PROPOSALS FOR
WOODFOLD VILLA
nr. BLACKBURN, LANCASHIRE
SPECIALIST DESIGN REVIEW COMMENT
PARA 80e

Jeremy Musson, MPhil, FSA

August 2022

First Floor.
WOODFOLD VILLA

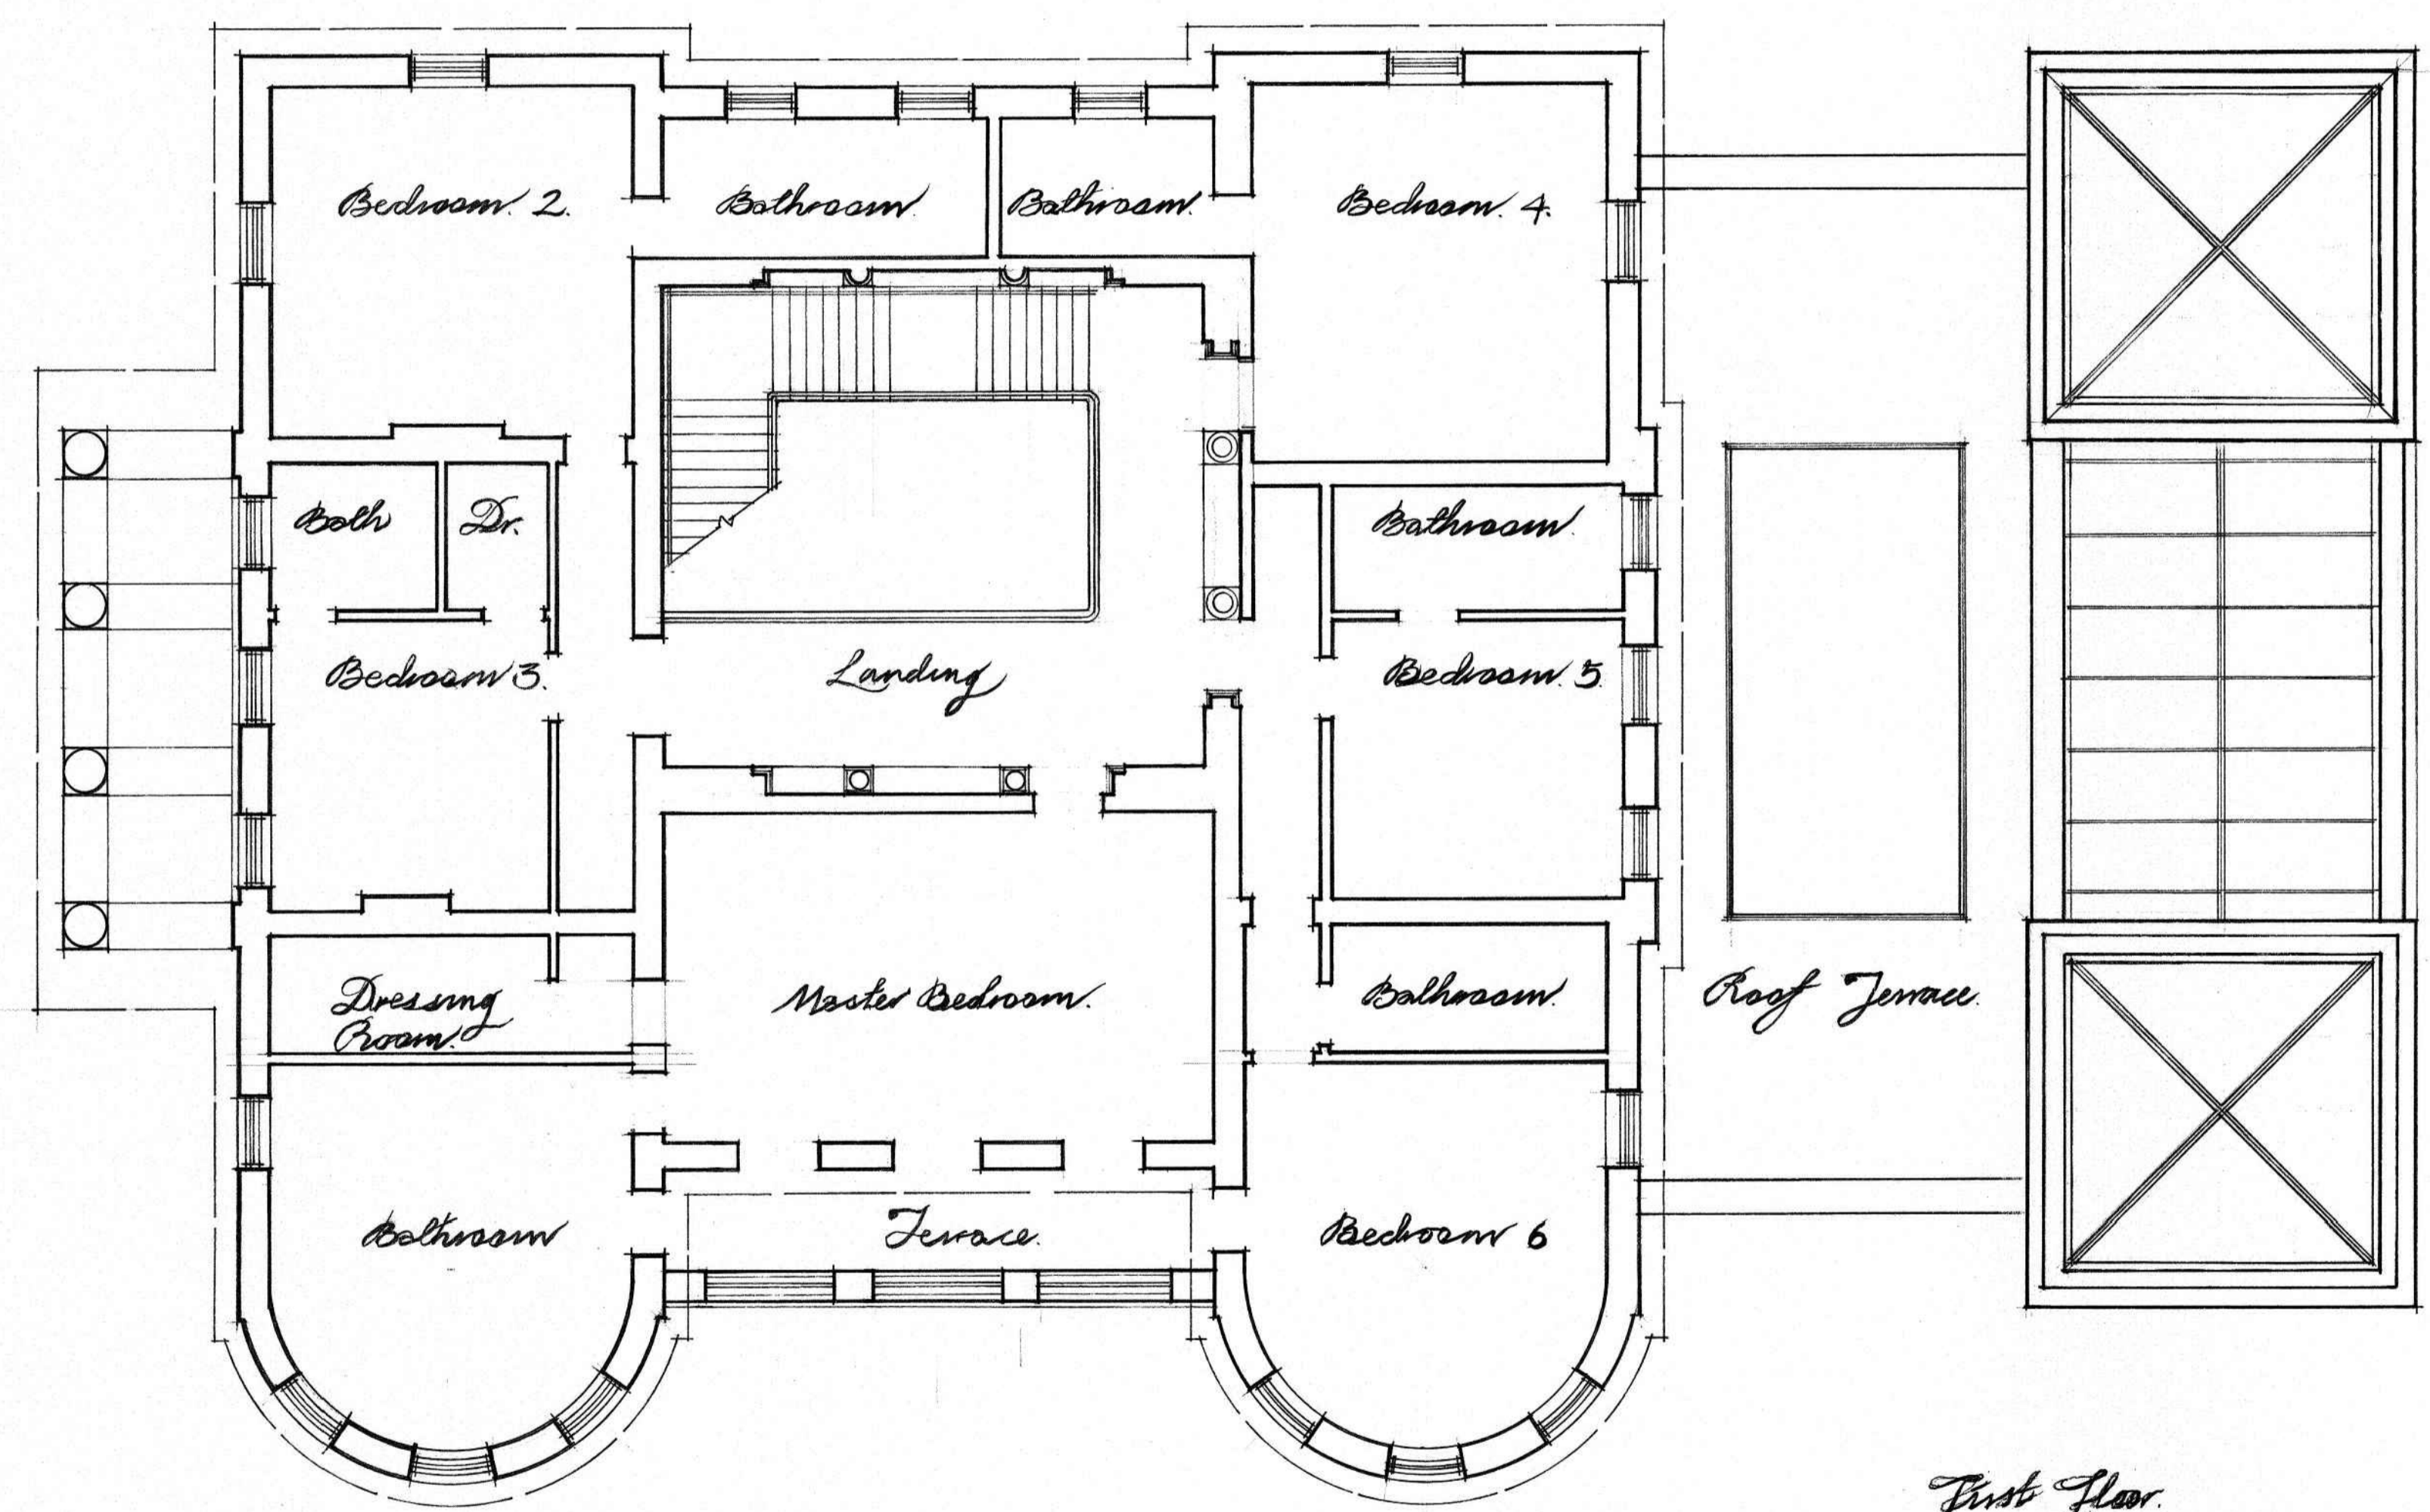
The interior plan is an exemplary arrangement broadly in the Regency country house tradition around a full height, galleried top-lit staircase hall, with a library, entrance hall and drawing room on the north side, and the dining room, kitchen/dining room (to the west) and orangery for informal social gatherings, and this is open to the pool house making a very pleasant and modern interior on the south side of the house (see overleaf).

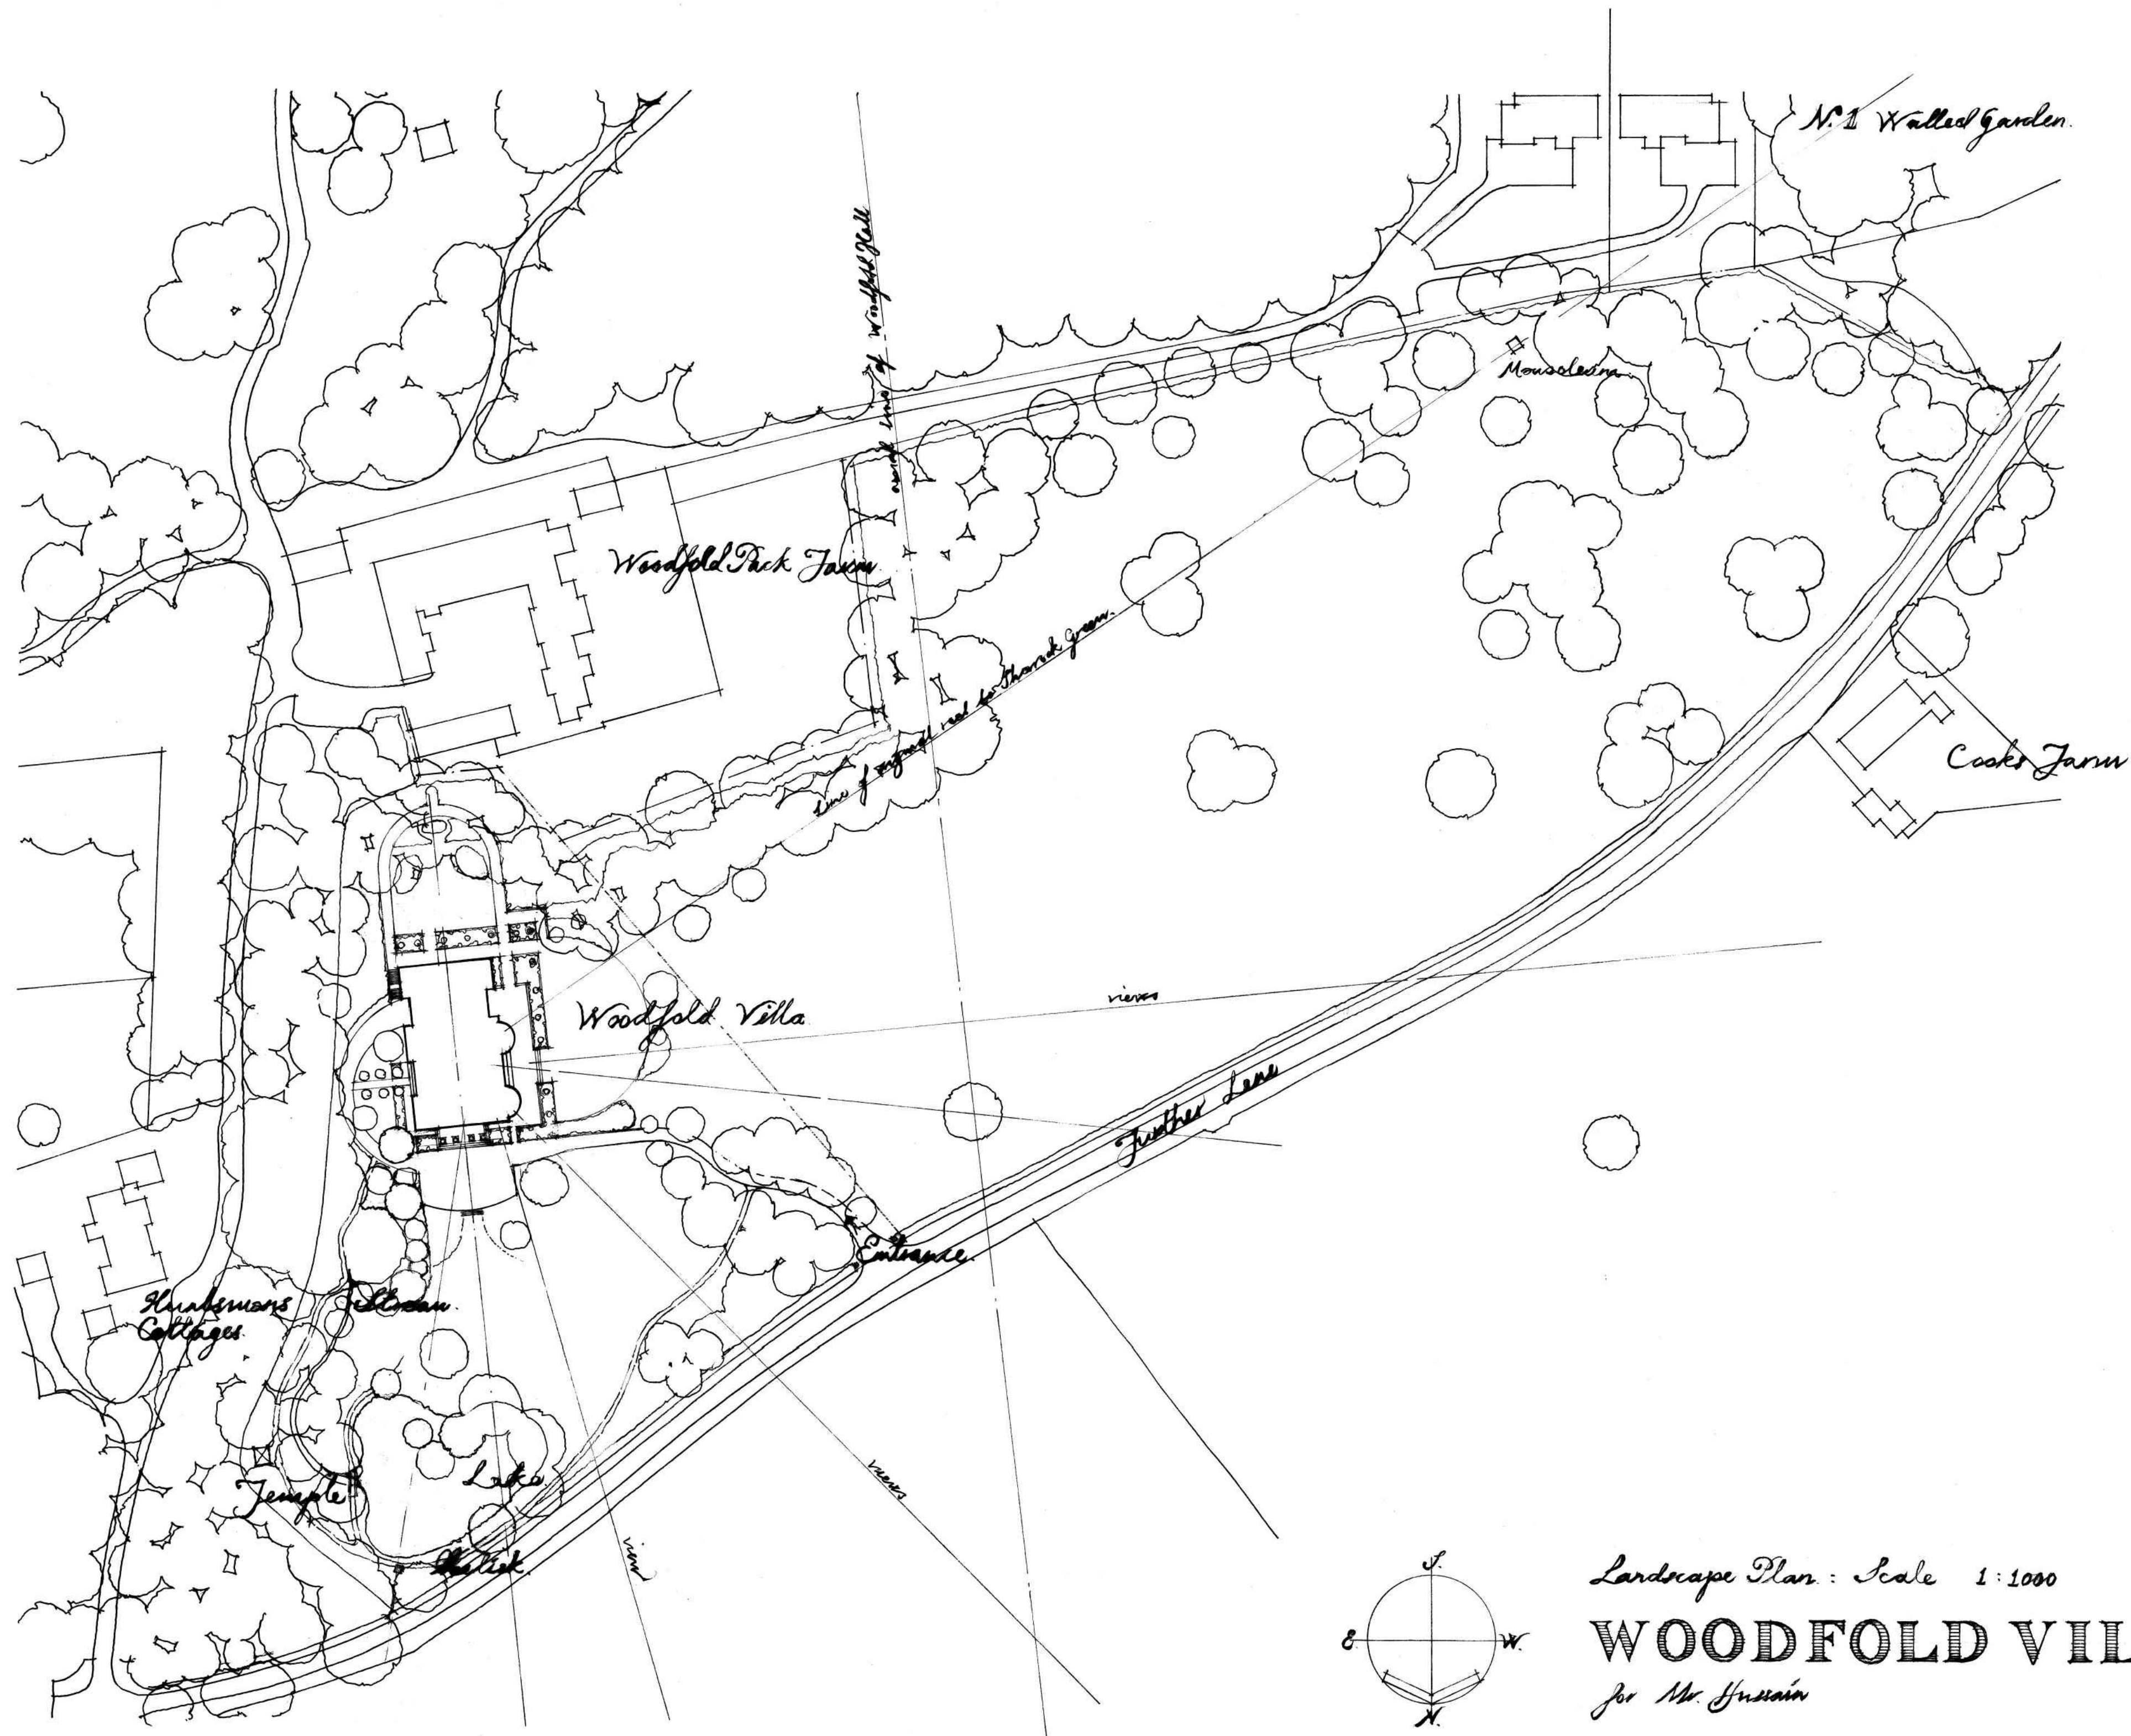
The proposed landscape plan makes full use of the existing tree back drop and introduces a substantial amount of new planting around the boundary of Woodfold Park Farm, and creating a new area of park with informal planting of single trees, between the site of the proposed house and Cook's Farm, all framed by the lane on the north west side.

Two garden buildings are proposed, and a lake and serpentine stream are proposed around the east and north of Woodfold Villa. Formal flower terraces are to be kept, in the Reptonian manner, only in the immediate vicinity of the house, ornamental shrubbery is proposed to enhance the setting of the new lake.
